TOWN AND COUNTRY PLANNING ACT 1990

Town and Country Planning (Control of Advertisements) Regulations 2007 ADVERTISEMENT

Reference:	H16-0319-26	Date of Decision:	28th May 2026
Applicant:	Blendly Hair Studio 1 New Road Spalding Lincolnshire PE11 1BS		
Location:	1 New Road Spalding Lincolnshire		
Description:	2 Fascia Signs & 3 Barbers Poles - Retrospective

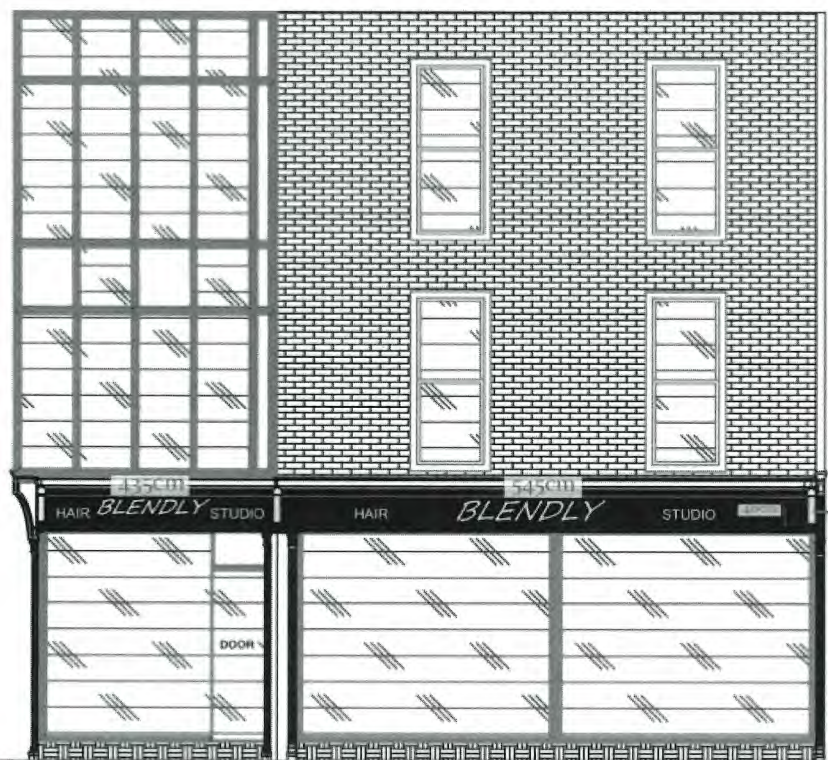
- 1 The proposed illumination, including the selection of changing colours, is considered to conflict with the prevailing character of the Conservation Area. The feature fails to preserve or enhance the historic environment, introducing an incongruous feature at odds with the established vernacular. The impact of this feature is exacerbated by the high level of illuminance proposed.

On this basis, less than substantial harm has been identified, in line with Paragraphs 212, 215 and 220 of the National Planning Policy Framework, December 2024. It is considered that the public benefits arising from this development do not outweigh the identified harm.
